Two storey side and rear extension, single storey rear extension & replacement front porch.

28 Arun Road Bognor Regis

Thank you for your internet representation made on 5th January 2020 which has been recorded as **'an objection'** with the comments as follows:

CLIENT	Mrs G Curtis	DRAWING	002 Proposed Plans & Elevations		
SITE	28 Arun Road, Bognor Regis	DATE	31 10 19	AUTHOR	AH
PROJECT	Proposed Extensions & Alterations	SCALE	1: 100 @ A3	STATUS	PRE PL

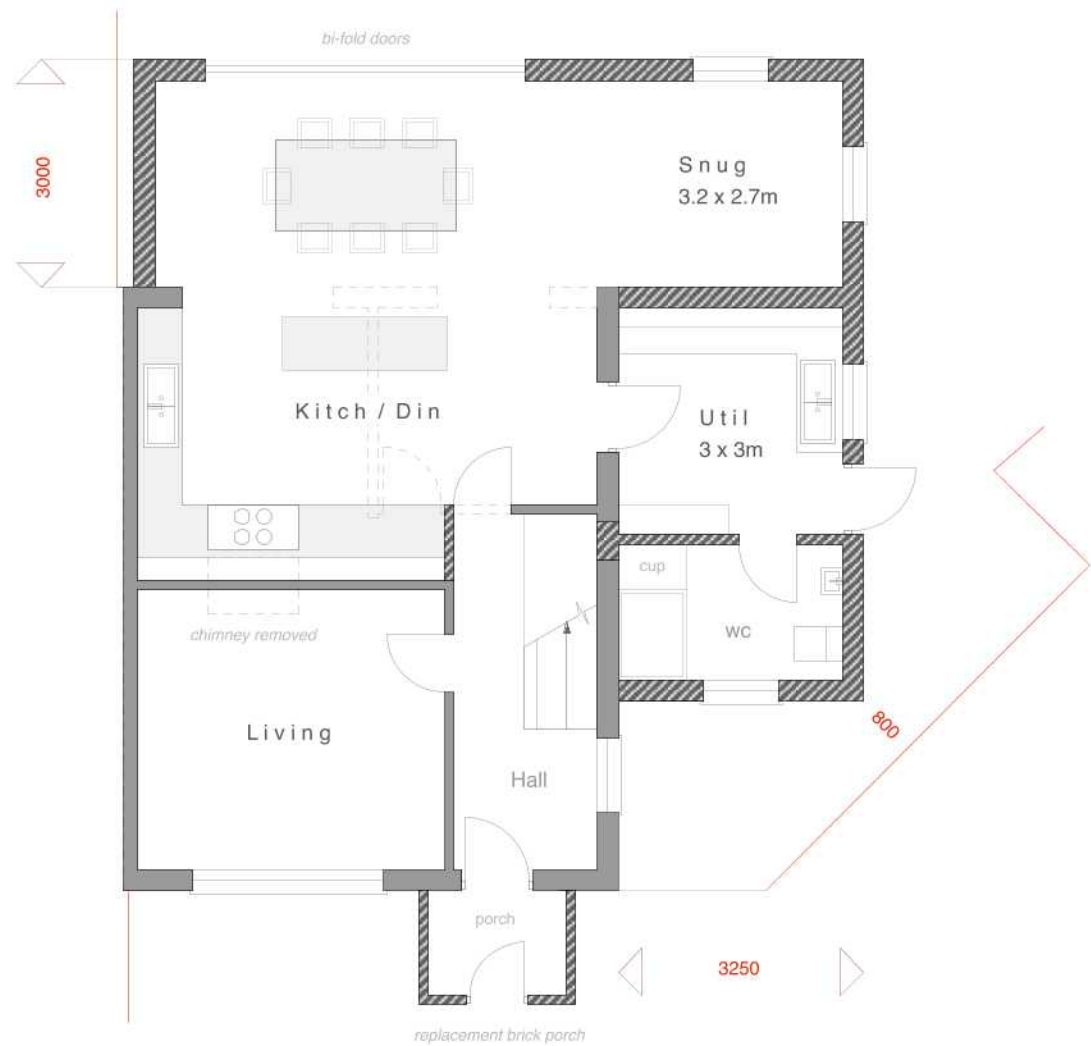
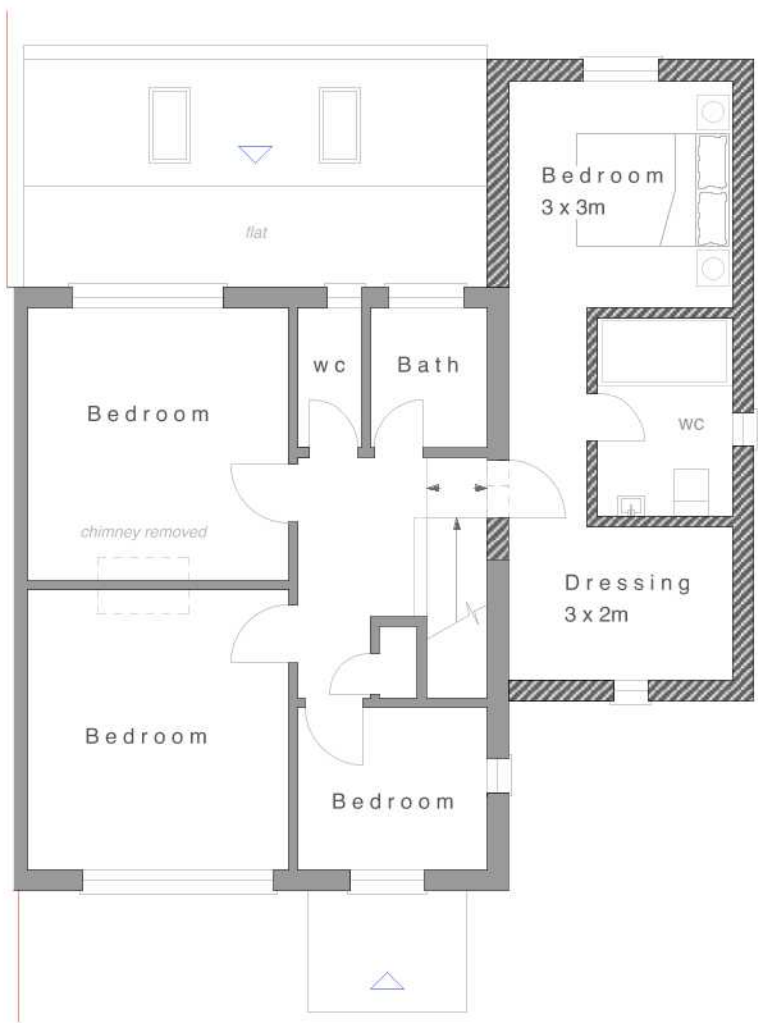
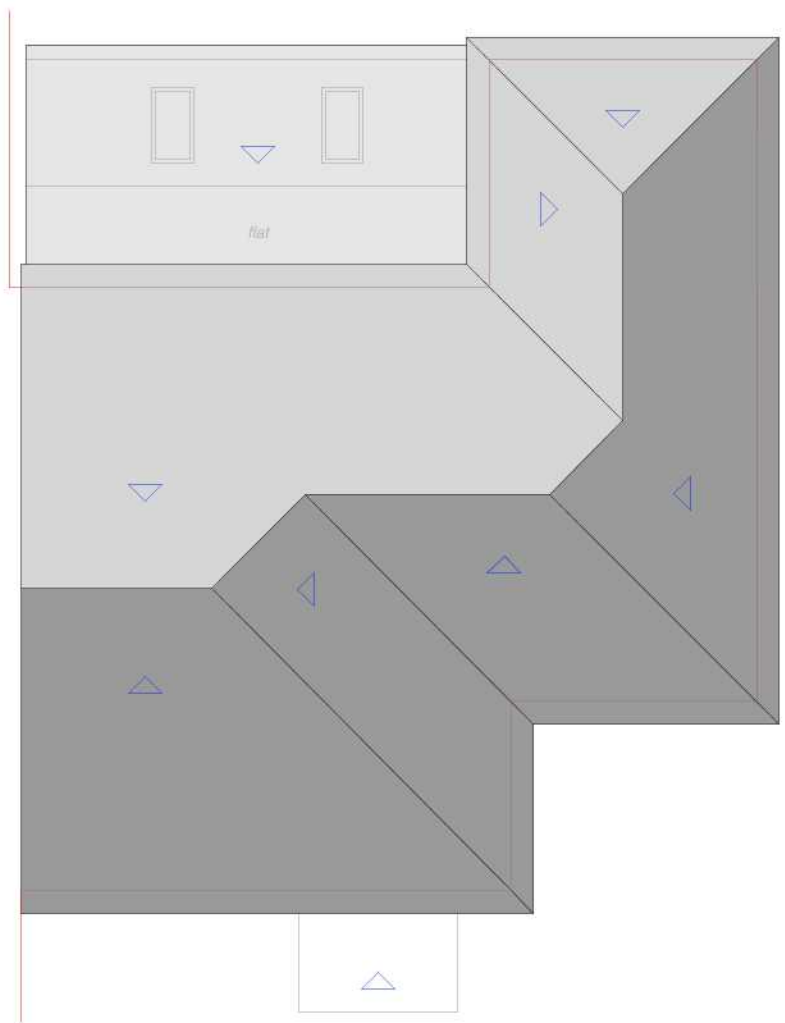
We also note you said in your report that our house that is attached to number 28 is set back from Arun road when in fact it's near enough in line with our neighbouring houses at 24 and 30 and we are as close to the pathway as anyone else so the proposed two storey side extension at number 28 would be highly visible from the street and would imbalance the street scene and the symmetry of the pairs of semi detached houses.
